**West Nowra Landfill Extension RtS – Response to further EPA comments
on Air Quality assessment**

This letter has been prepared to address the NSW Environment Protection Authority's (EPA) request for further information (in the letter dated 15th November 2019) on the Air Quality assessment undertaken to support the Environmental Impact Statement (EIS) and Response to Submissions (RtS) for the proposed West Nowra Landfill Extension SSD 7187.

Shoalhaven Landfill Extension Response to EPA Submission

Figure 9 Proposed Landfill Cell Sub-Stages Layout

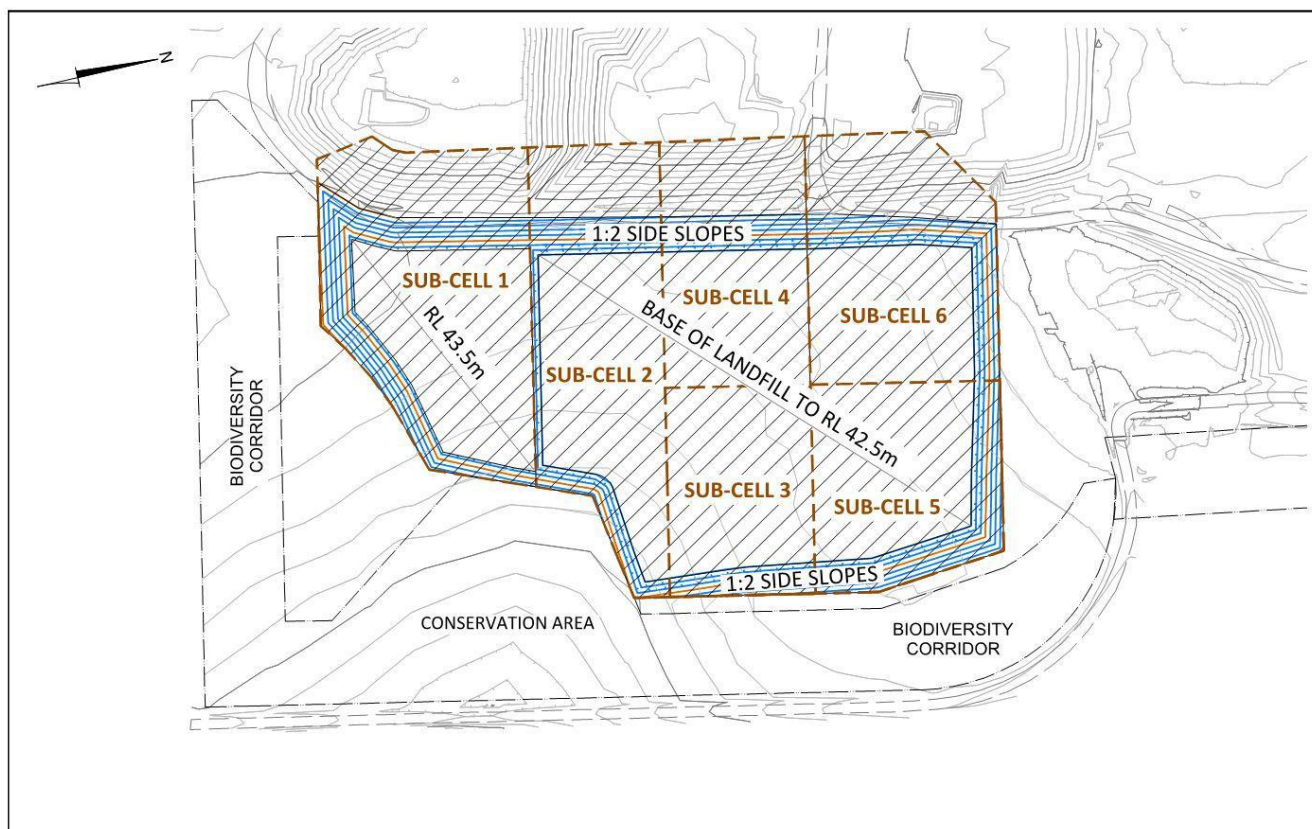
During the additional assessment, it was identified that in the original Air Quality Impact Assessment, there was a typographical error in the label and emissions reported for Stage 4 landfill sub-cell 1 – intermediate cover. As a result of this error the Surface Odour Emission Rate (SOER) for the intermediate cover area was modelled as the same SOER as daily cover, which is considered to be unrealistically high for intermediate cover areas. As shown within Attachment A, when remodelled with a more realistic SOER, the odour criterion of 5 ou is not exceeded at either of the R1 or C2 receivers.

Upon review however, the use of the daily cover SOER for intermediate cover areas is considered to be unrealistically high and gives a disproportionate contribution for this source compared to the other landfill sources. As part of this updated modelling therefore, the SOER used for intermediate cover areas in the previous air quality impact assessment for West Nowra Landfill (*West Nowra Recovery Park EIS – Air Quality Assessment*, GHD, 2015) of $0.0841 \text{ ou.m}^3/\text{m}^2/\text{s}$ has been used. This value was sourced from an odour audit performed at the Lucas Heights Waste and Recycling Centre in 2006, and was used in this updated modelling instead of the value of $0.04 \text{ ou.m}^3/\text{m}^2/\text{s}$ reported for intermediate cover areas in the Eastern Creek Landfill monitoring survey, which is based on one sample only and could therefore potentially underestimate emissions from this source. For consistency, the SOER used for the other Stage 4 sub-cells was also updated from $0.04 \text{ ou.m}^3/\text{m}^2/\text{s}$ to $0.0841 \text{ ou.m}^3/\text{m}^2/\text{s}$.

- For the proposed landfill extension scenario, the intermediate cover area is a major contributor to both the combined maximum and 99th percentile odour predictions at both R1 and C2. The area used in the modelling for intermediate cover is still very conservative as it includes sub-cells 2-6 as well as the remainder of sub-cell 1 (ie the area other than that allocated as the active face and the daily cover area).

Figure 11 Source Locations Assumed for Assessing Potential Worst Case Odour Impacts

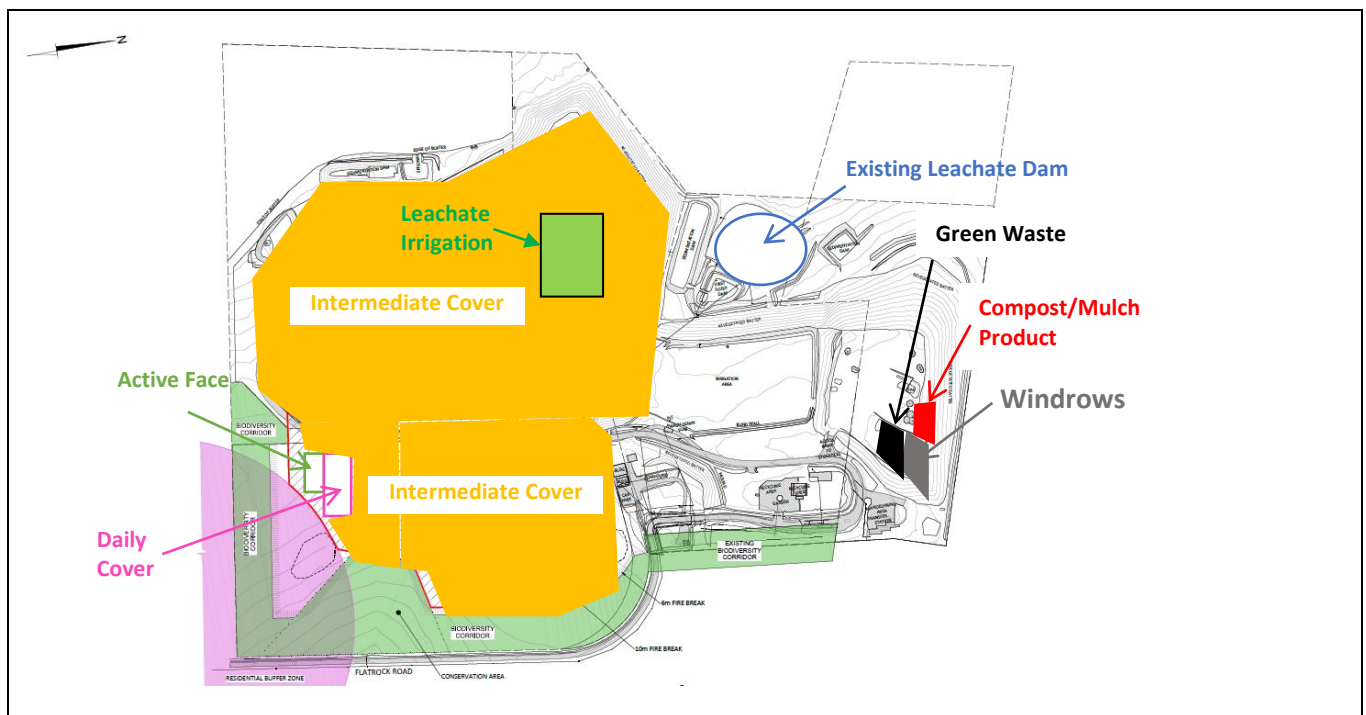
<p>4 <i>Comment:</i> The RtS does not explicitly commit to not cause offensive odour beyond the site boundary. Regardless, the Environment Protection Licence and Section 129 of the POEO Act outline regulatory responsibilities to not cause offensive odour beyond the boundary.</p>	<p>This commitment must be made by the proponent, not SLR. No further response required.</p>
<p>5 <i>Comment:</i> TA-Air notes that no contingency measures have been nominated. Comments regarding contingencies measures are provided to assist a proponent in their ability to comply with Section 129 of the POEO Act. Regardless, TA-Air considers that the proponent should investigate mitigation measures to reduce the modelled risk of odour impacts, as discussed previously in the advice.</p>	<p>Addressed in section 2.6 below.</p>

For the proposed landfill extension scenario, the 99th percentile odour concentrations are predicted to increase by a factor of 3 at R1 and by a factor of 4 at C2. This increase is associated with fugitive emissions from the intermediate cover area. For the current and proposed maximum odour concentrations predicted at C2, odours from the shredding and screening activities in the composting area are also a significant contributor. This would therefore suggest that should complaints be received from C2, the most appropriate mitigation measure would be to postpone shredding and screening activities until the recurrence of favourable meteorological conditions. Based on the modelling the most appropriate mitigation measure for R1 would be ensuring that the intermediate cover is placed and maintained to minimise odours from this source and that completed cells are covered with final cover as soon as practicable.

In performing this analysis, it was identified that in the original Air Quality Impact Assessment (AQIA), there was a typographical error in the label and emissions reported for one source in Table 14 for the landfilling operations. This table had the Surface Odour Emission Rate (SOER) for the “Stage 4 landfill sub-cell 1 – final cover” source set at $0.04 \text{ ou.m}^3/\text{m}^2/\text{s}$. This source should have been labelled “Stage 4 landfill sub-cell 1 – *intermediate* cover”. In addition, as shown in Table 13 of the AQIA, there was only one sampling result available for intermediate cover, which gave a comparatively low SOER of $0.04 \text{ ou.m}^3/\text{m}^2/\text{s}$, the same as the average SOER measured for final capped areas. To address this in the original AQIA modelling, the Stage 4 landfill sub-cell 1 intermediate cover area was actually modelled with an SOER of $2.16 \text{ ou.m}^3/\text{m}^2/\text{s}$ (same as daily cover).

Figure 22 Predicted 99th Percentile Nose-Response Odour Concentrations (Includes Leachate Irrigation)

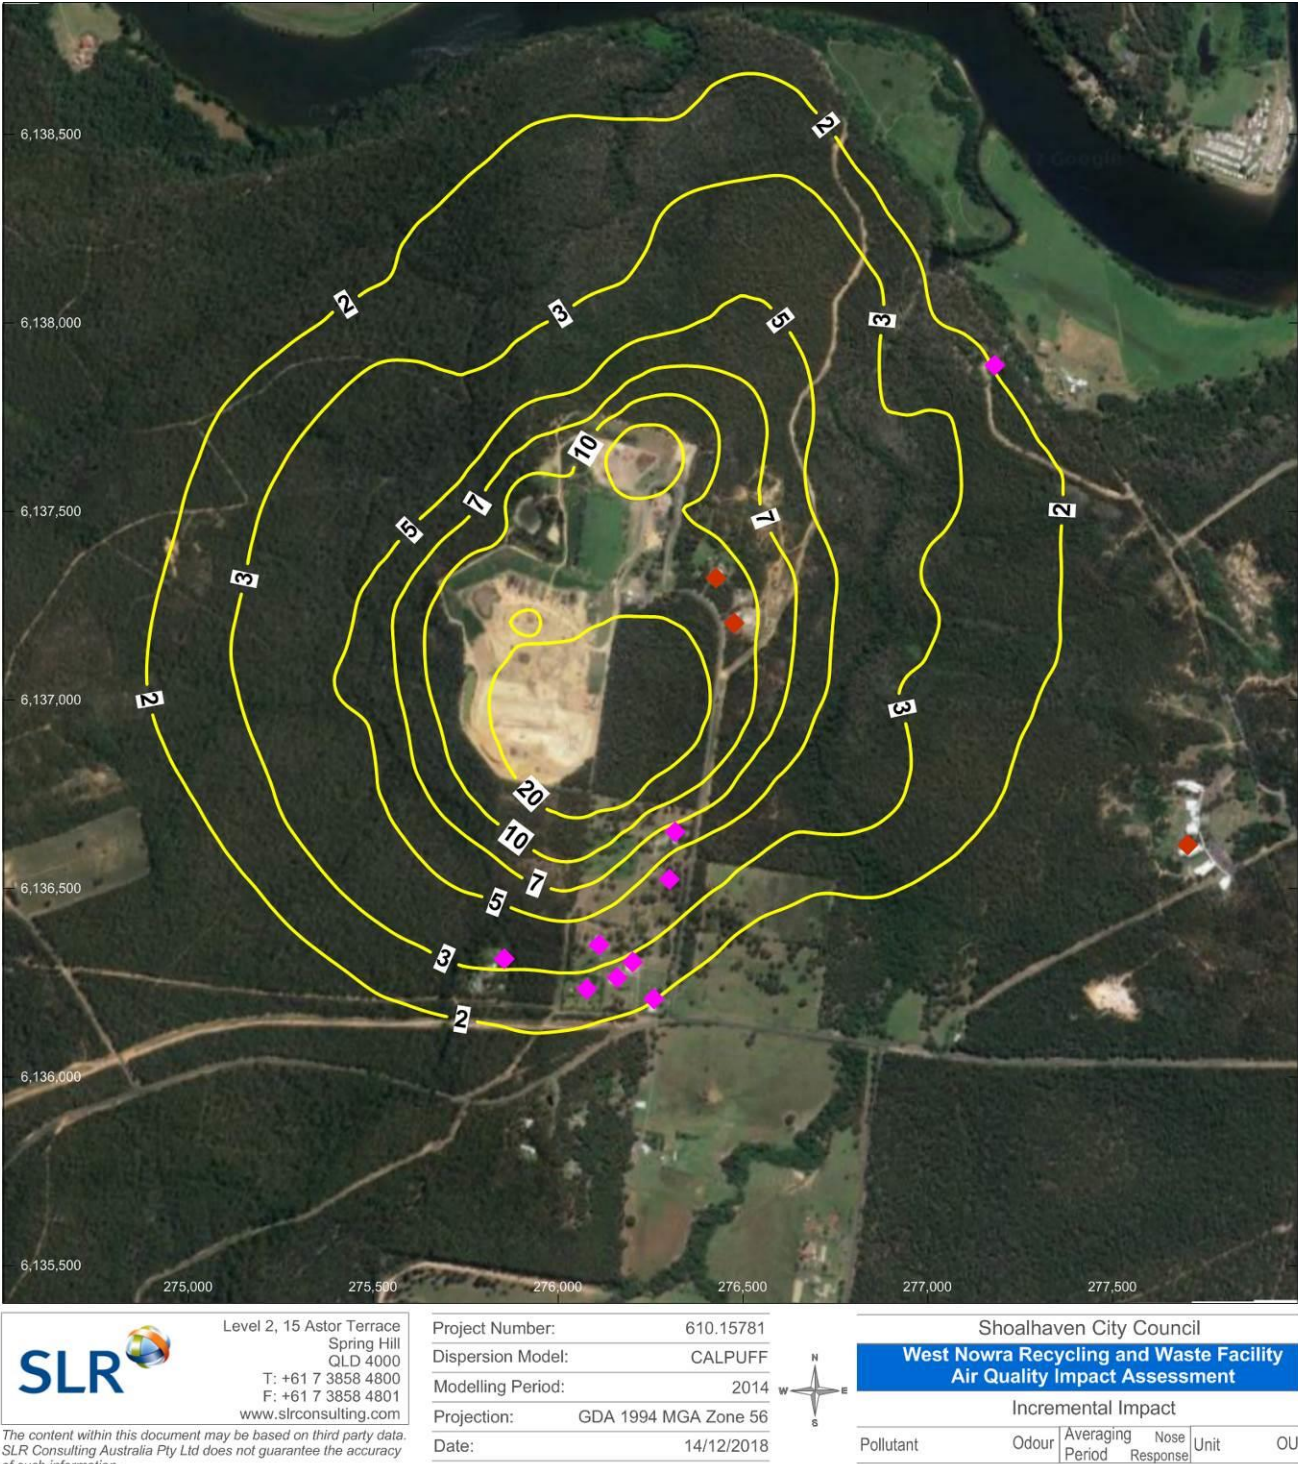
EPA Comment/Request	Response
<p>3 <i>Recommendation:</i> The proponent be requested to:</p> <ol style="list-style-type: none"> 1. Present predicted odour impacts for both C2 and R1 accounting for average and maximum odour emission rates for the landfill area, daily cover area, leachate dam and irrigation area; 2. Where exceedance of odour impact assessment criteria are predicted, the proponent must investigate mitigate measures. In considering mitigation measures the proponent should include interrogation or analysis of individual source contributions to predicted odour concentrations 3. Present additional modelling incorporating the mitigation measures identified to demonstrate compliance with the impact assessment criteria adopted for the project. 	<p>It is noted that TA-Air agrees that where a landfill gas extraction system is implemented with due diligence on identifying and rectifying issues with capping and containment, odour emissions from the capped areas could be managed. And that as such, the odour emissions from the final capped areas in stages 2, 3 and 4 can be excluded from the modelling to provide a more realistic emissions scenario for the proposed operations.</p> <p>SLR also wishes to clarify that the intent of the additional modelling using average emission rates is to show the sensitivity of the results to this conservative assumption. The average emission rates simply represent the average of the available data and are not required to be linked to any specific mitigation measure, as suggested in the TA-Air response.</p> <p>It is also noted that Commercial Receptor C2 is on land zoned SP2 Infrastructure, as are the existing and proposed Landfills at West Nowra. The Objectives of Zone SP2 are to (1) provide for infrastructure and related uses, and (2) to prevent development that is not compatible with that or may detract from the provision of infrastructure. It is therefore considered inappropriate for the odour nuisance criterion for sensitive receptors to be applied to this receptor. To require it to meet a sensitive receptor odour criterion would mean that it is considered to be a use that does not meet the objectives of the zone within which it is located.</p> <p>Nonetheless, SLR has performed additional modelling and analysis to provide the additional information requested by TA-Air. This information is provided in Section 2.</p>

As shown in **Table 3**, for the proposed operations, the odour criterion of 5 ou is not exceeded at either R1 or C2 when the emissions from the final capped areas in Stages 2 and 3 are excluded and the sub-cells 2-6 of Stage 4 are modelled with a revised SOER for intermediate cover areas consistent with the previous odour assessment performed for the site. The concentrations predicted are significantly lower than those presented in the AQIA and those presented in SLR's letter dated 16 October 2019. This is due to the reduction in the SOER used for the intermediate cover area.

The absence of any significant odour complaints history for the current operations is consistent with the low odour concentrations predicted for the current emission scenarios. However, now that the conservative assumptions regarding odour emissions from intermediate cover areas have been revised, the results predicted for the closest receptor locations are lower than might be expected given the relatively small separation distances, and are much lower than the previous results presented in the AQIA. This is discussed further in **Section 2.5**.

As noted in **Section 2.3**, now that the conservative assumptions regarding odour emissions from intermediate cover areas have been revised, the 99th percentile results predicted for the closest receptor locations are much lower than the results presented in the AQIA. It is possible that the emissions are now slightly underpredicted, however as there have been no complaints recorded in relation to normal operation conditions (ie outside of isolated abnormal wet-weather operating conditions) it is equally possible that the results for the current operations scenario are a fair reflection of existing odour levels. As shown in **Figure 1**, while the 99th percentile predictions would be undetectable at R1 and C2, there are hours in the early evening, night time and early morning when odours may be detectable at C2, which is a reasonable expectation given its close proximity to the site.
